From: Daun Johnson on behalf of Planning.Responses
Sent: 30 September 2026 11:17
To: Laura Mills
Subject: FW: Request for further information BR/171/26/PL
Attachments: 3635(C)02 ELEVATIONS AS PROPOSED.PDF; 3635(B)02 ELEVATIONS AS EXISTING.PDF; DSC09801.JPG; DSC09798.JPG; DSC09804.JPG; DSC09811.JPG

RE: BR/171/26/PL

Rear West Elevation as Proposed
Scale 1:50

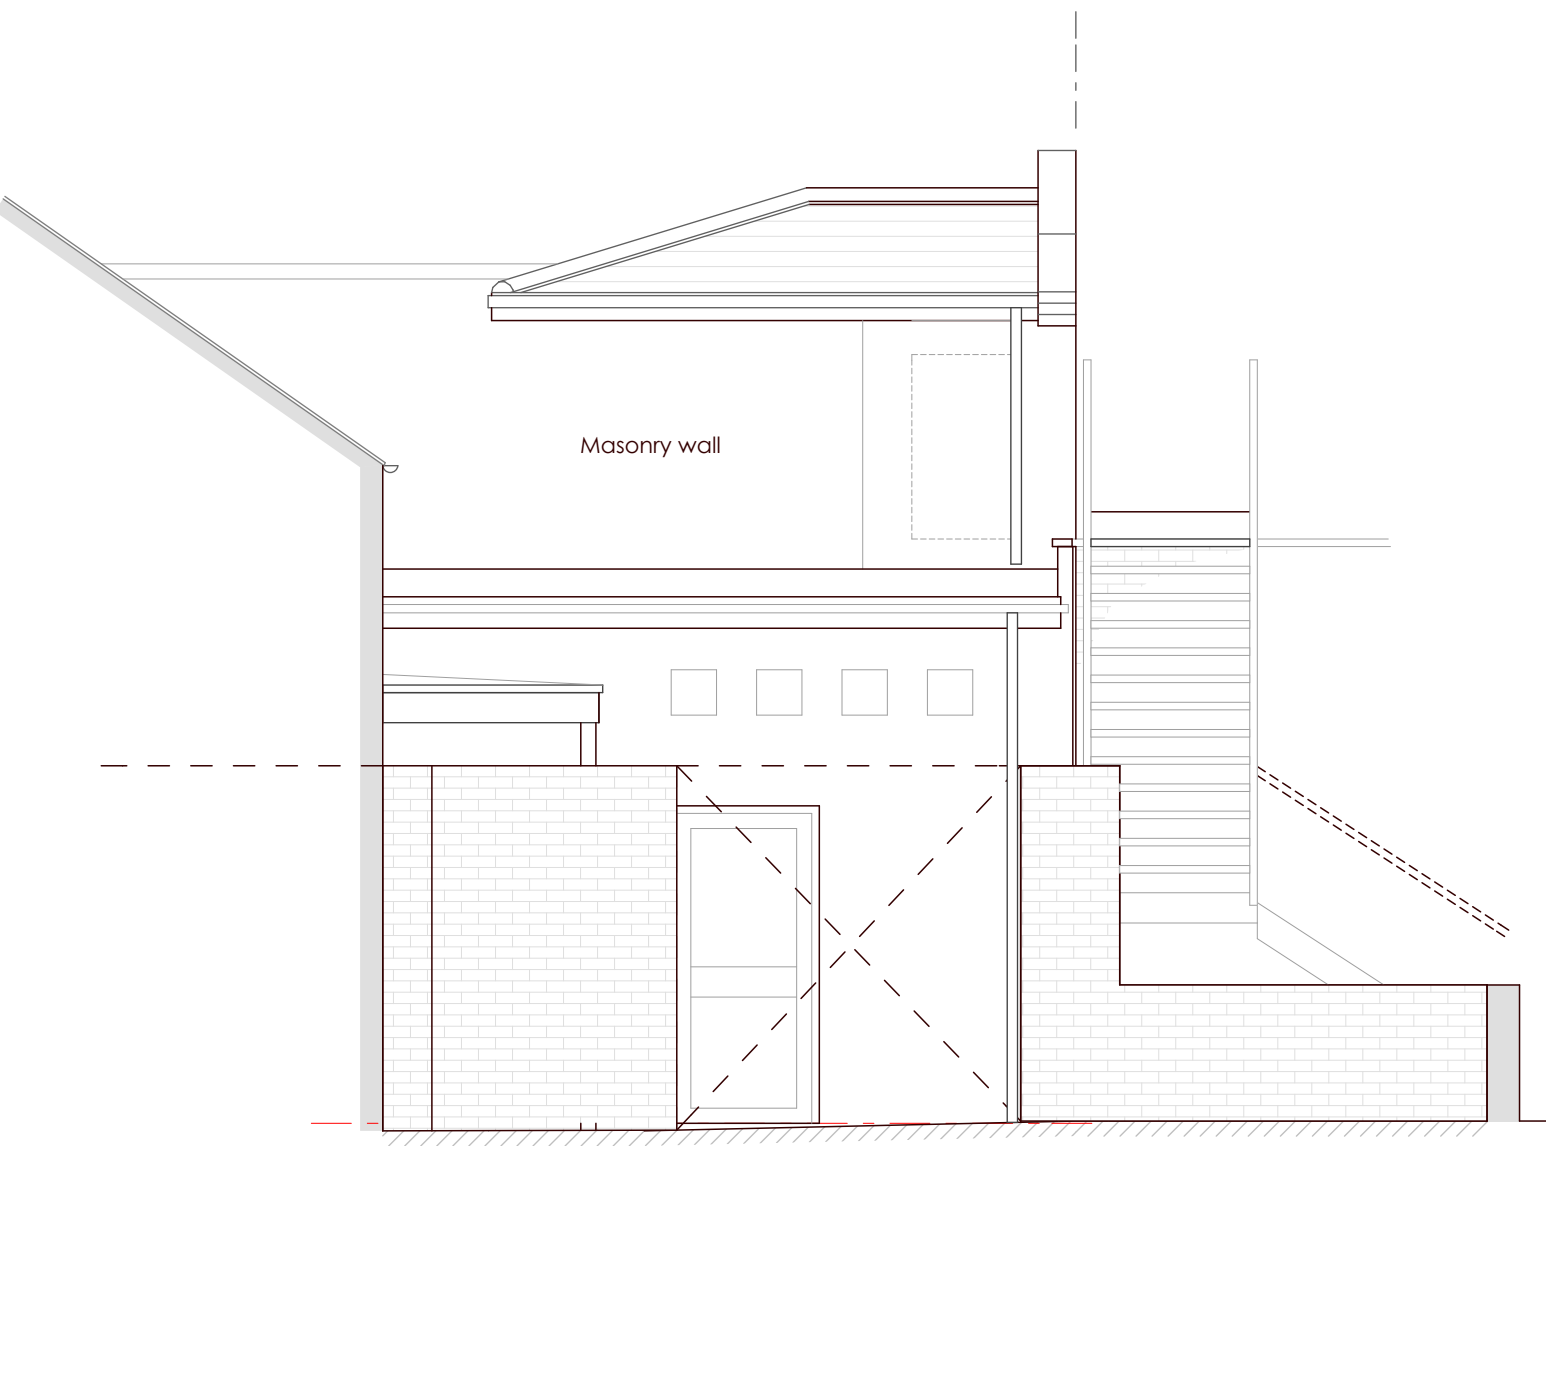
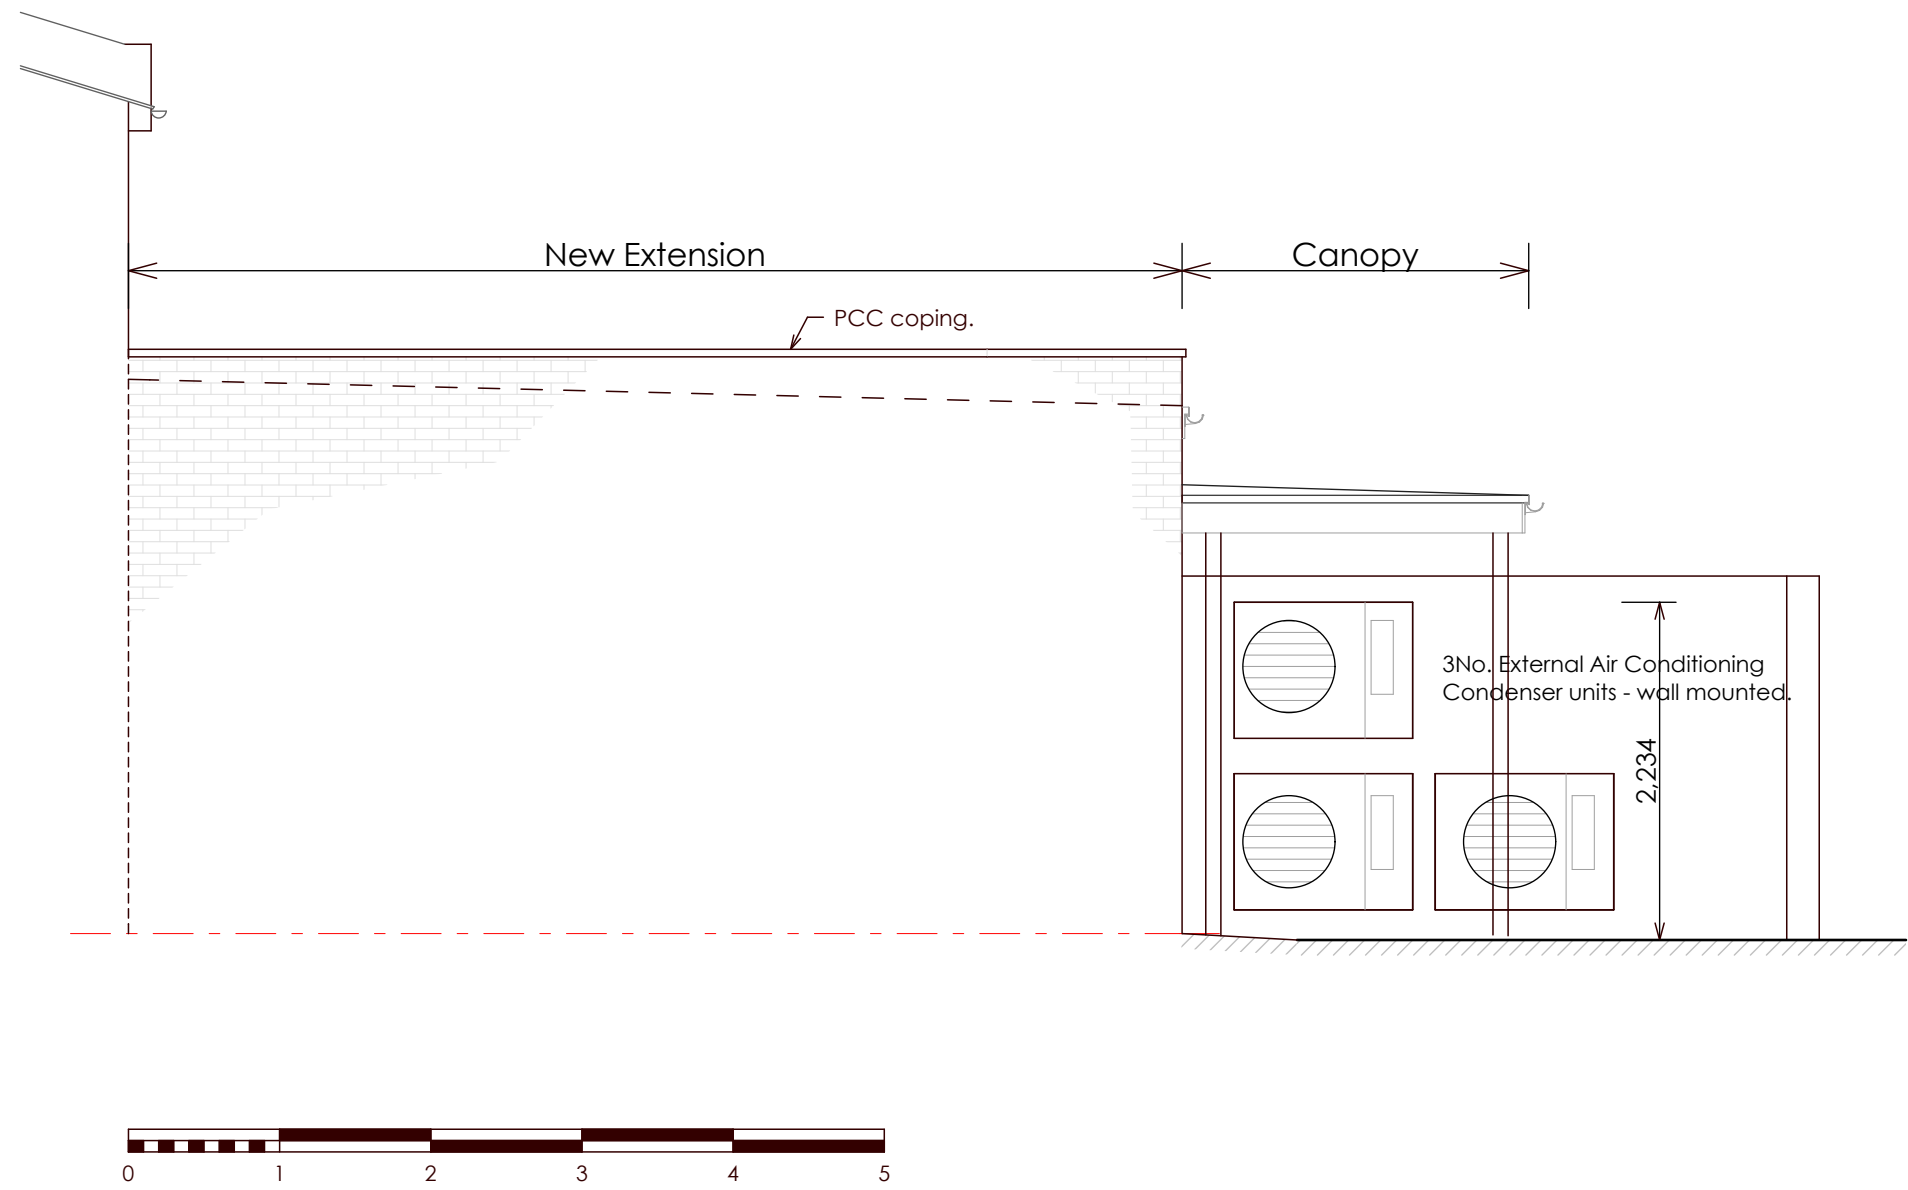
There also seems to be some misunderstanding when reading the submitted drawings.

The 2x West Elevations are correct. They are both the same elevation but taken from different perspectives for clarity. (What you would see close up and what you would see from the road. (There is currently an external wall & a building blocking the view from the road - as indicated).

Rear South Elevation as Proposed
Scale 1:50

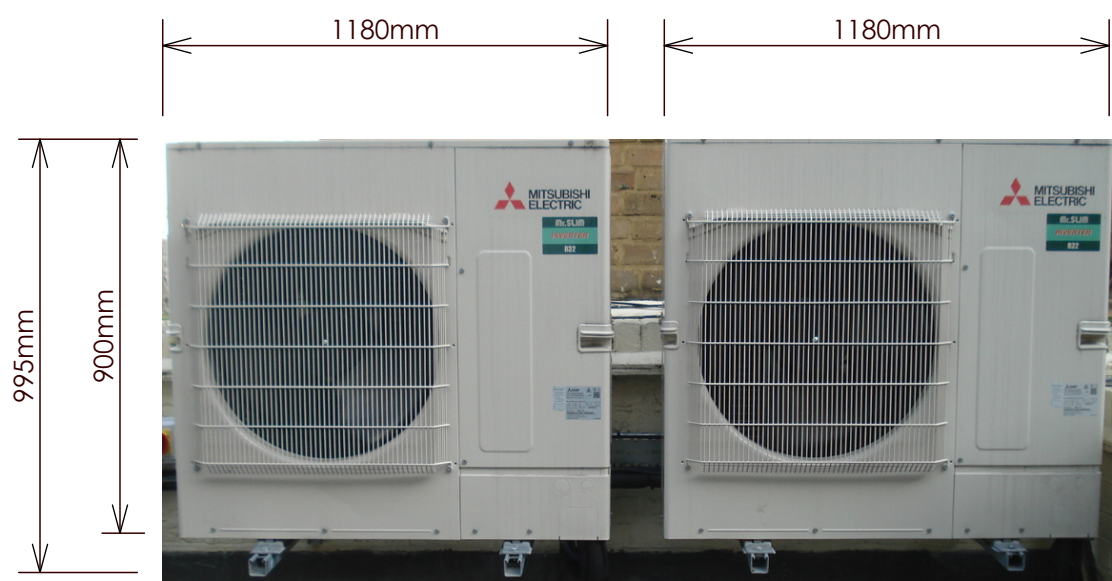
We have amended the proposed South Elevation slightly to show the approx. sizes of the condensing units in relation to the rear wall. (attached). The photographic image to the RHS is not intended to be

to scale....it is a photo representation of what they will look like with actual sizes shown. (If they were shown smaller at 1:50 you would not make them out).
